**ADC Planning Consultation  
Response from the Historic Buildings Adviser**

| <b>Application Number</b> | BE/13/12/L                                        |
| <b>Address</b>            | The Chase, Bognor Regis                           |
| <b>Description</b>        | Repairs to west facing gable wall, remove chimney |

'The Chose' 101 North Bersted Street
Elevations - proposed
Drawing no. 2011-50-02

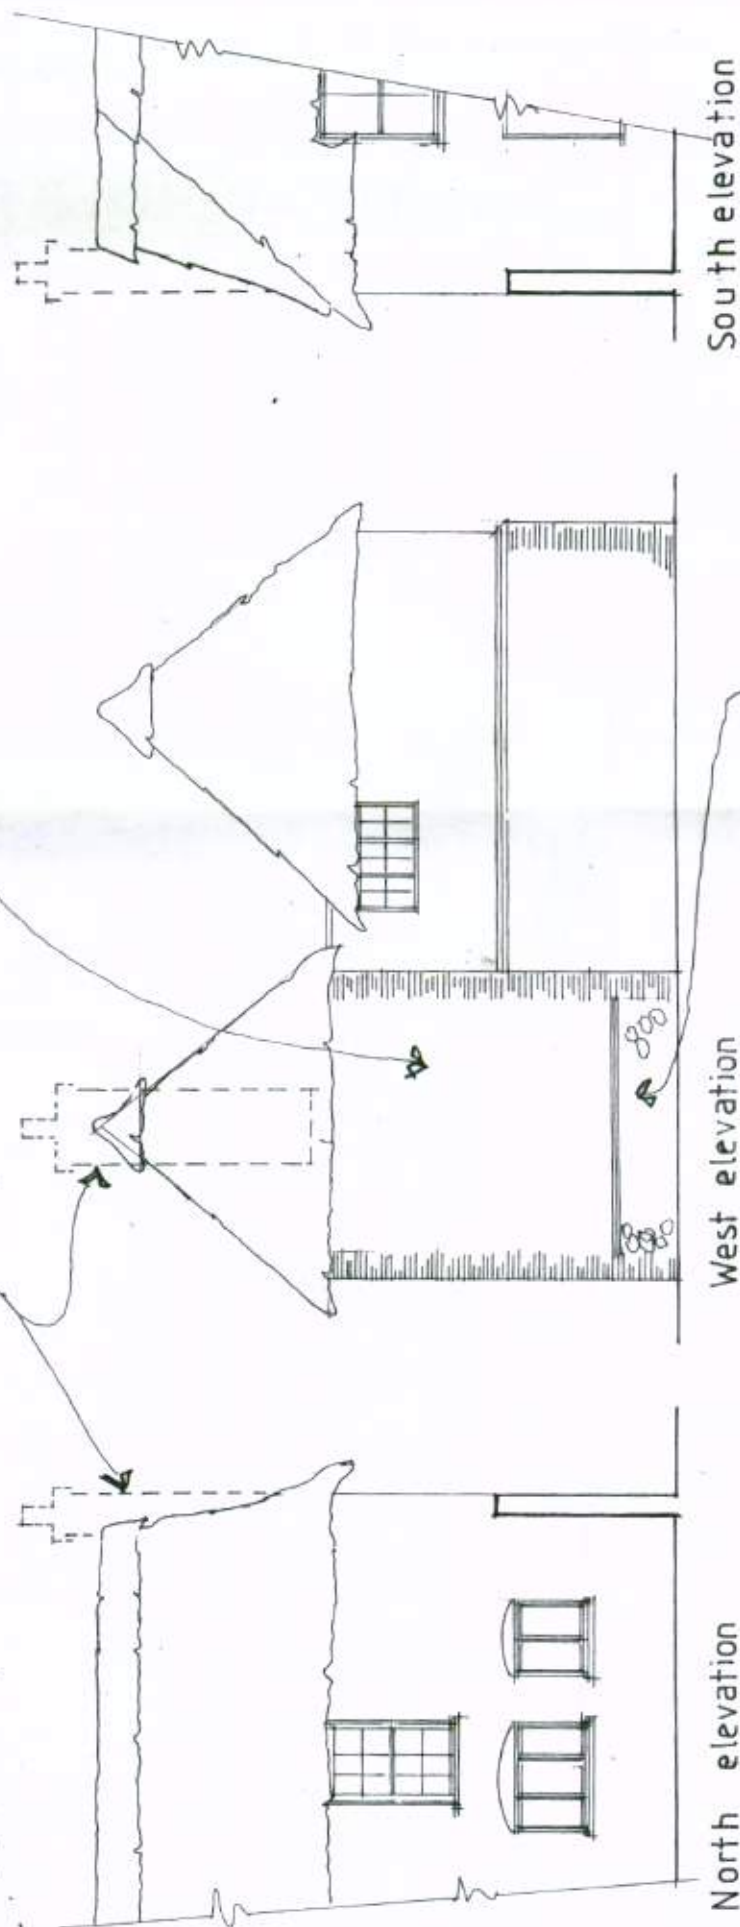
The removal of the chimney is acceptable on the basis that it is compromising the structural integrity of the gable wall and that as a feature itself, is not of any particular age or merit.

The treatment of the elevation below however, seems overly harmful and results in an excessive loss of historic fabric as well as character. The brickwork and stonework here provides historical evidence which should be retained where at all possible. This is in accordance with the requirements of PPS5 which seeks retention of as much historic fabric as possible. Where stone work cannot be replaced, bricks should be used instead. I am not convinced with the potential use of lime render on block work and would recommend that this be avoided. The rebuilding of the wall here should be in lime mortar.

I confirm that I have now discussed Mr. Wightman's recommendation with my client who is willing to accept the amendment requested.

I attach a pdf copy of revised drawing no. 2011/50/02A showing the amendment.

NO.	BE	13	12	12

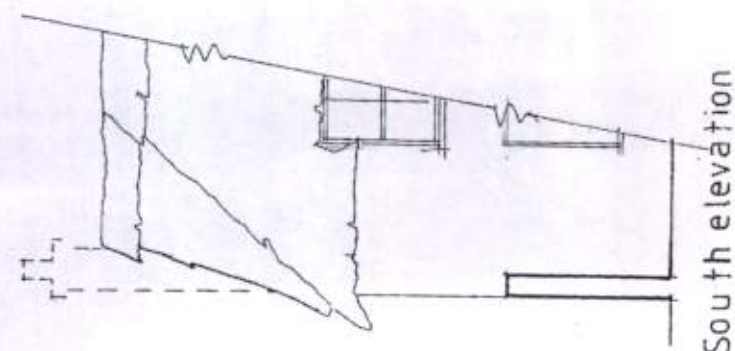
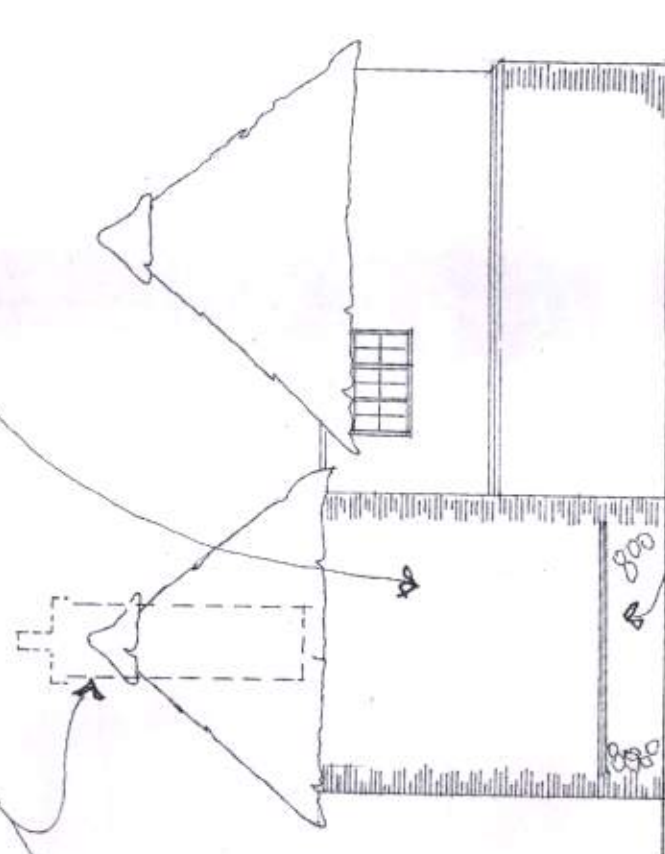
This is fine. We need to condition the mortar which should be ~~the~~ lime with aggregates. lime strength should probably be NHH3.5. They should seek to match existing in colour and texture.

Further to receiving the amended drawing for repairs to The Chase, I still have concerns regarding the way the wall is to be repaired and its appearance.

The HBA comments provided thus far have asked for more of the existing fabric to be retained and where material is lost, brickwork (or stone for that matter) to be used to make up the shortfall. The desired effect would be to maintain some evidence of the chimney in the wall, not to replace the upper section of the wall, all in brick.

27.3.12

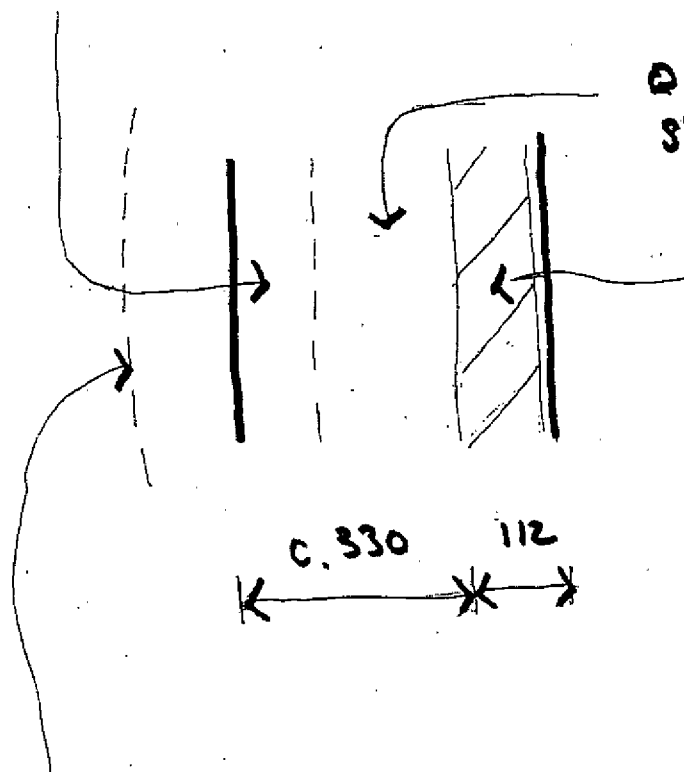
Having read the engineer's report I would be interested to see a typical section through

the wall to understand the structure. It would appear that there is an inner and outer skin, when I would expect solid masonry.

Further to your email earlier today I now attach a section showing the make up of the wall.
